Your Ref: OWPC306
Our Ref: EP/61/13/NMA 13-05-2013
Please ask for:
Mrs A Gardner

Application for a non-material amendment following a grant of planning permission
EP/21/10 - Regency style ornamental gates added to entrance of development in
addition to ornamental metal railings between brick piers with stone caps & pedestrian
access gate with corresponding access path

Nursery Close Manor Road East Preston

Drawing Title
Entrance gates and railings

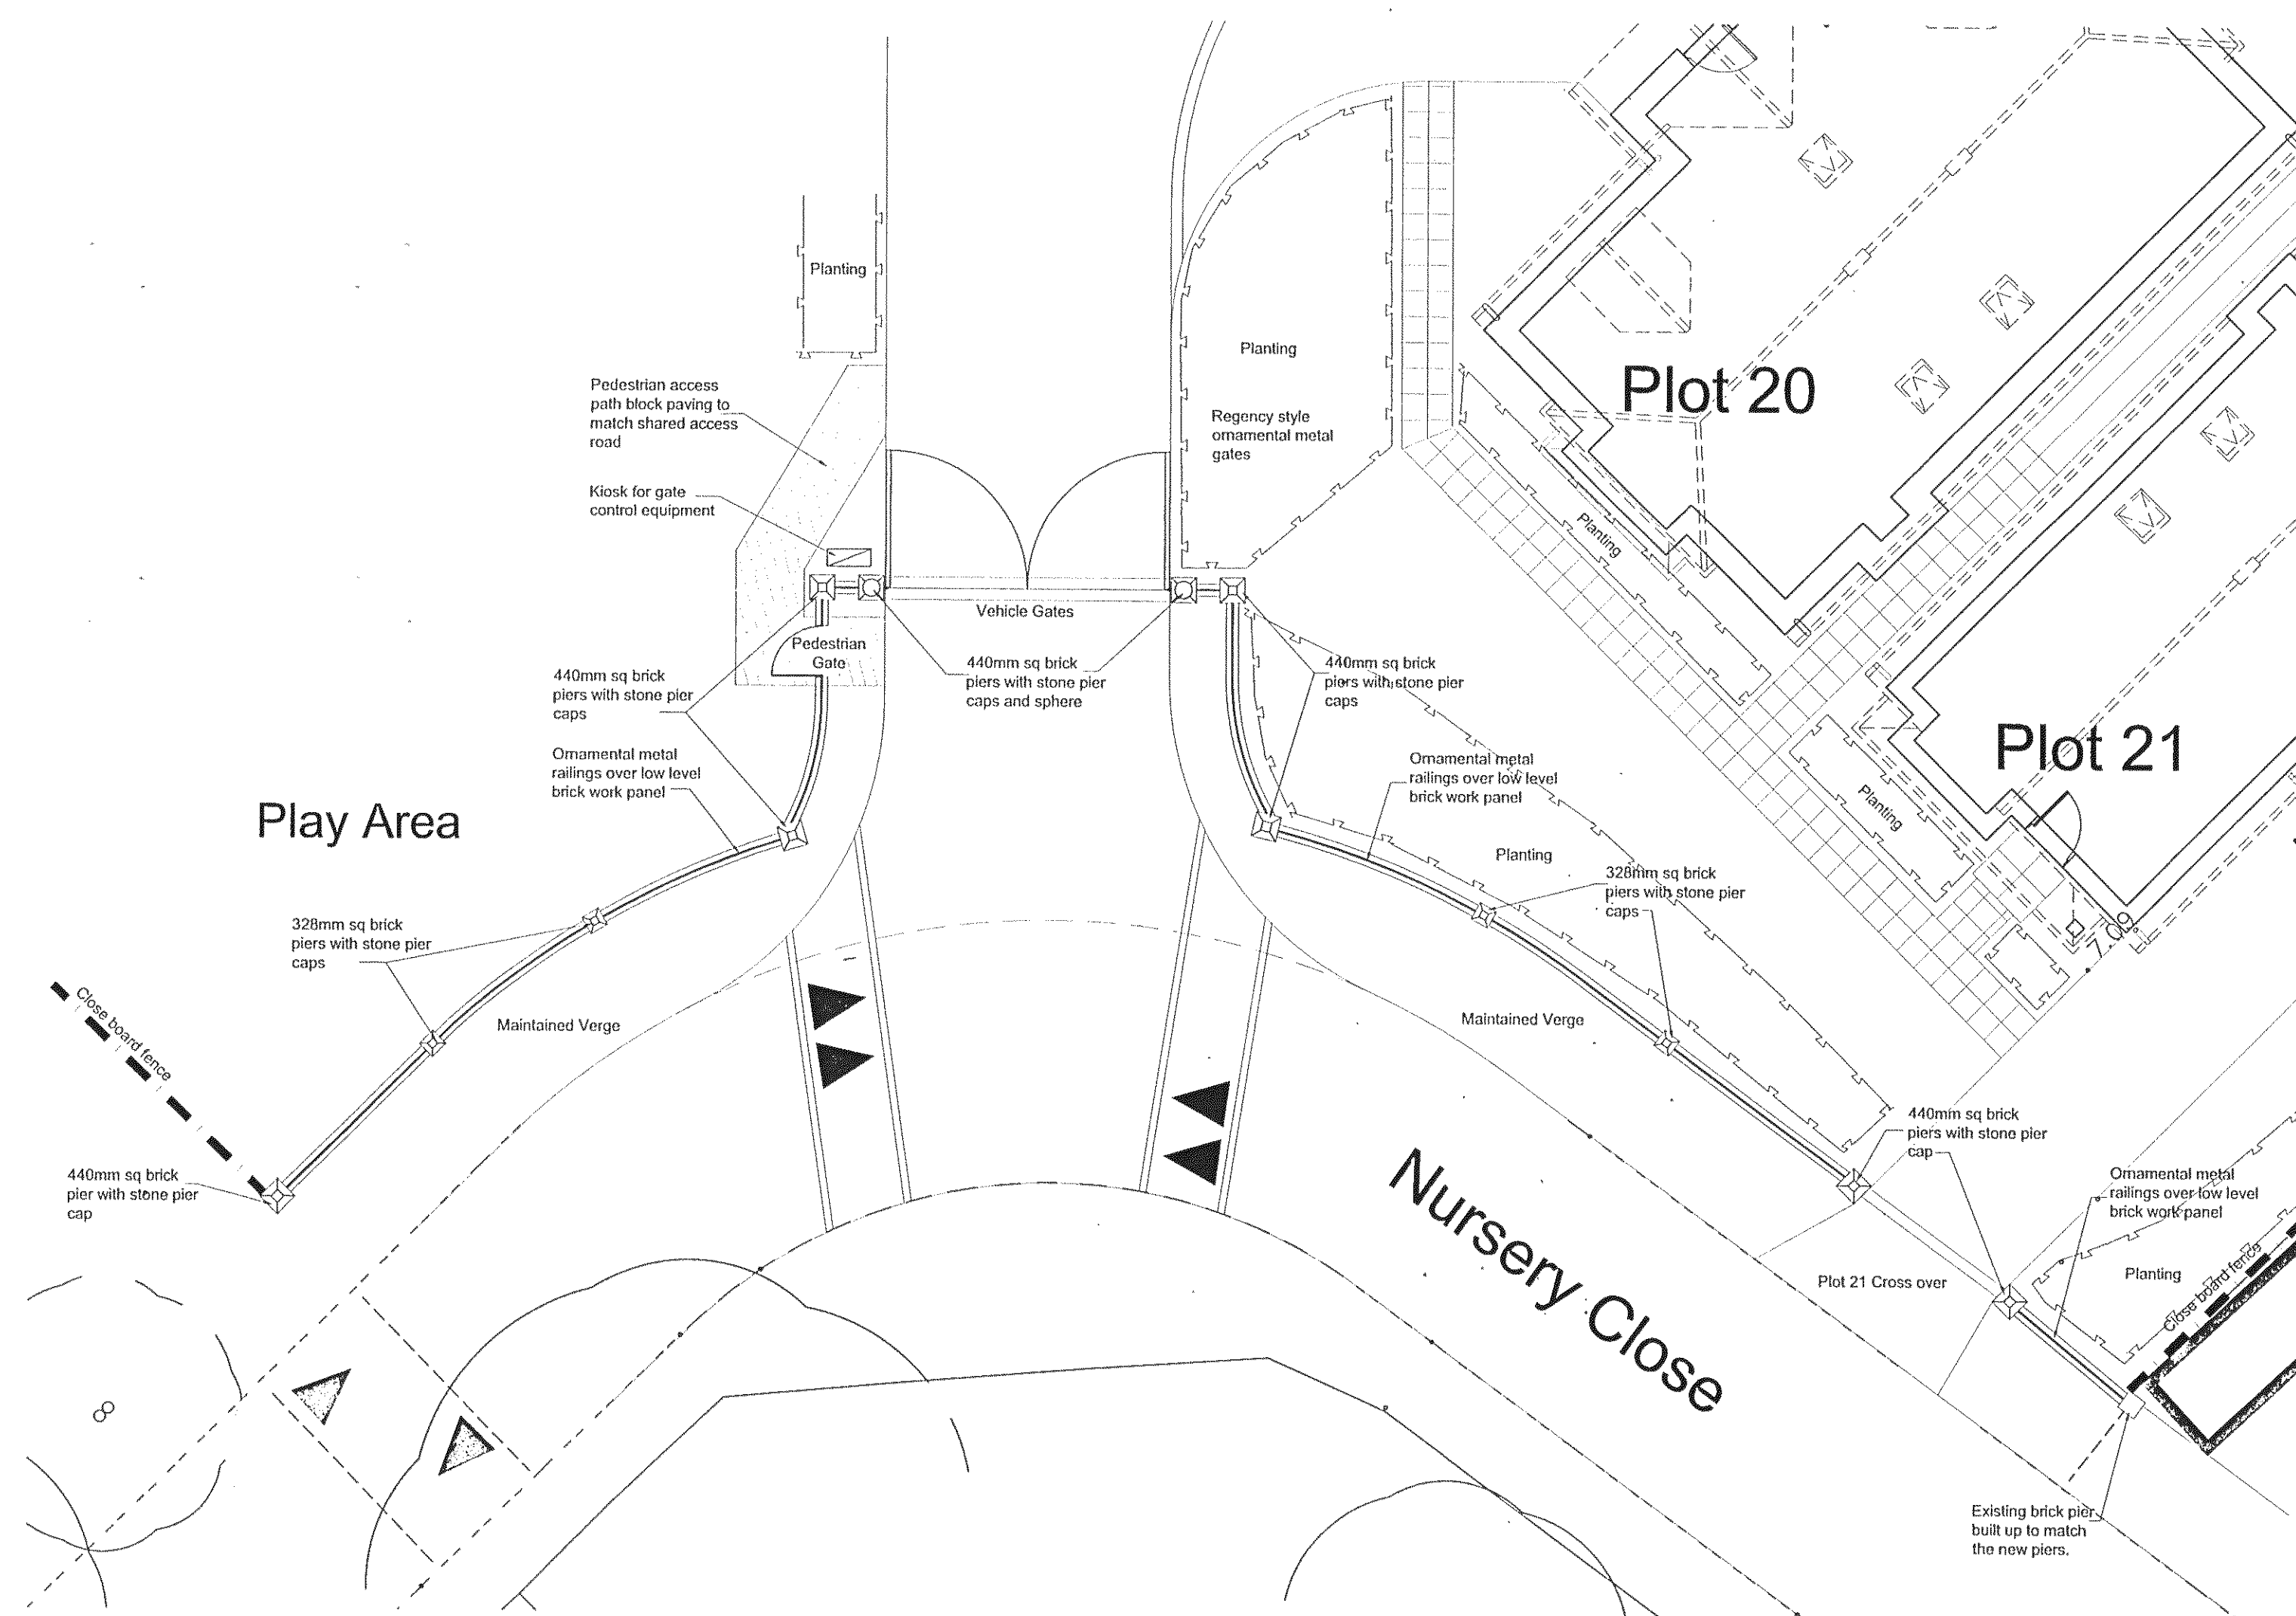
*The proposed gates and wrought iron fencing will not only give a significant adverse visual
impact but cause restricted access to the area of play which is for use by all local
residents not just Beltane close residents.*

*The proposed gates will cause significant congestion to nursery close resident access as
the vehicles ,especially trade and service vehicles such as waste disposal and recycle
lorrys will have to park in the narrow road to await the gates to open blocking access for
emergency vehicles and residents transport some of which use disability scooters.*

*The proposed fencing between pillars is contrary to the design of adjacent residents
where a covenant exists to restrict wall height to two feet adjacent to the roadway and this
was why the original plans restricted the wall height.*

*It is possible that this covenant is being breached by this new proposed wall height and
pillars as well as the railings .*

*The visual effect of these new proposals will significantly alter the open outlook of we have
tried to maintain in our village and this new gated and enclosed site will do nothing to
enhance the development except help the developer to sell the houses as a enclosed
community .*
